REF: 21/00255/FUL

Location: 28 St Martin's Road Oxford OX4 4RS

22 February 2021

Drawing Number
444SM-PLA- 010

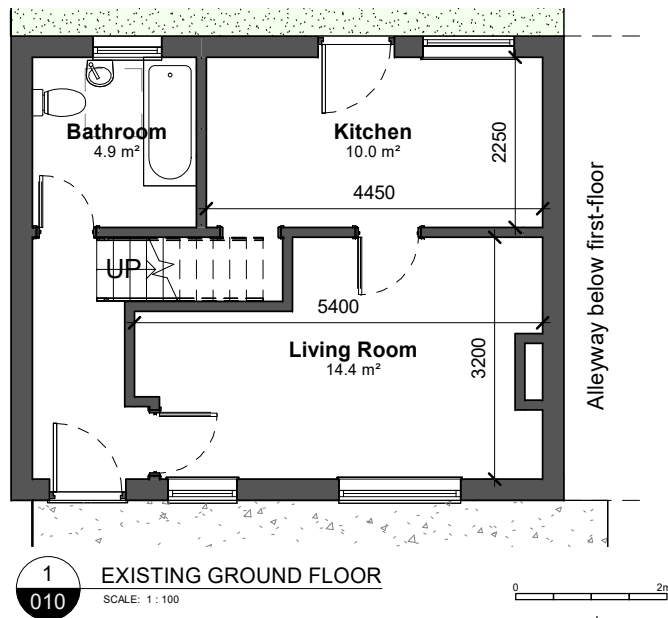
I am unable to find any details pertaining to security measures within this application, which is essential in demonstrating that residents within the HMO will be able to live in a safe and accessible environment where crime and disorder, and the fear of crime will not undermine their quality of life or community cohesion. Prior to planning approval being granted, I ask that plans are amended and submitted to the local planning authority, which will include the following;

- In line with building regulations part Q, I ask that all bedroom doors must be certified to PAS24, with a door viewer installed.
- Due to the crime levels in the surrounding area, I ask that all ground floor bedroom windows are constructed with laminated glass.
- A secure postal strategy is required. A single letter box in the external door set is inappropriate and it should be remembered that not all offenders are external to a development. Postal services should be provided through:
 - Secure external post boxes with surveillance from the dwelling to this area or
 - Through the wall delivery into individual secure mail boxes.
- A visitor notification system (doorbell), ideally with two-way audio should be provided for each resident, to assist all occupants in maintaining a safe and secure quality of life without being unreasonably disturbed by other occupants' visitors.

Drawing Number
444SM-PLA- 001

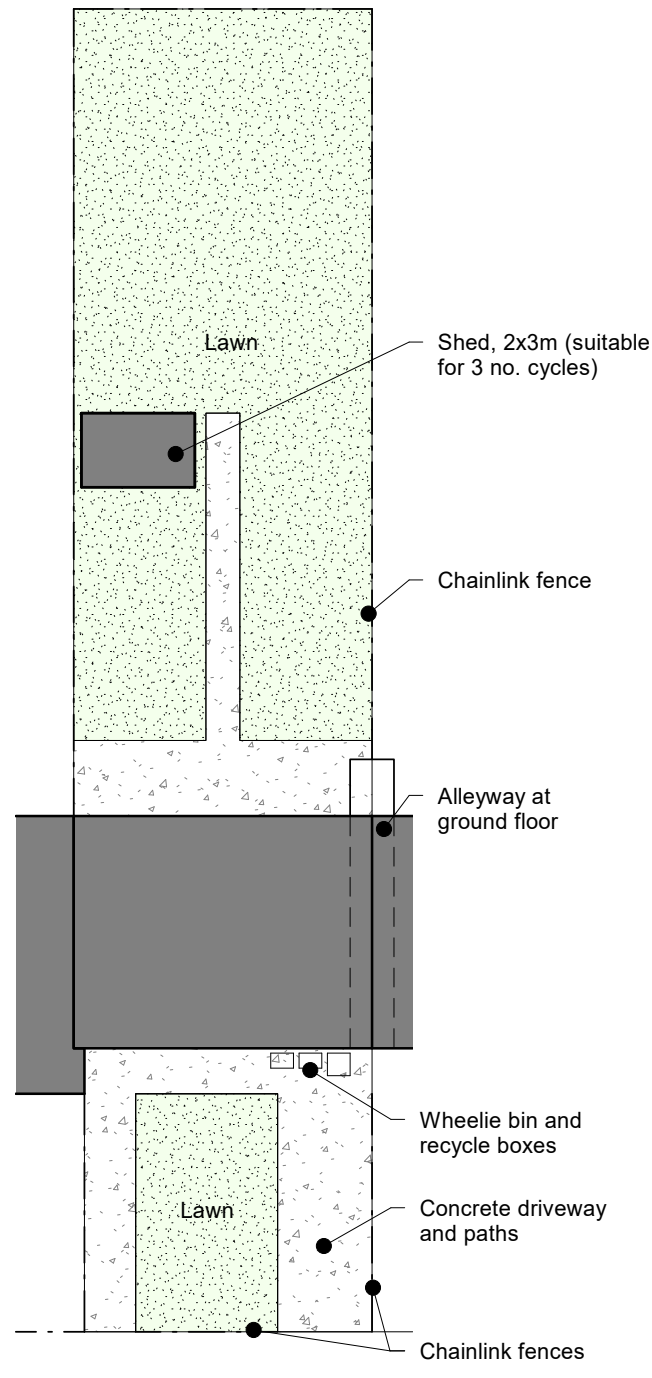
It is reasonable to assume that residents of this building will want to have access to cycles. This application does not provide details of what type of cycle store will be provided for residents.

- I ask that secure cycle storage is provided, which taking into account crime statistics for the area should be certified to a minimum of LPS 1175 SR1. Failure to do this may result in residents resorting to bringing cycles into the dwelling and storing them in corridors, which would present a fire egress risk. Details of cycle storage should be provided in plans and approved by the local planning authority prior to permission being granted.
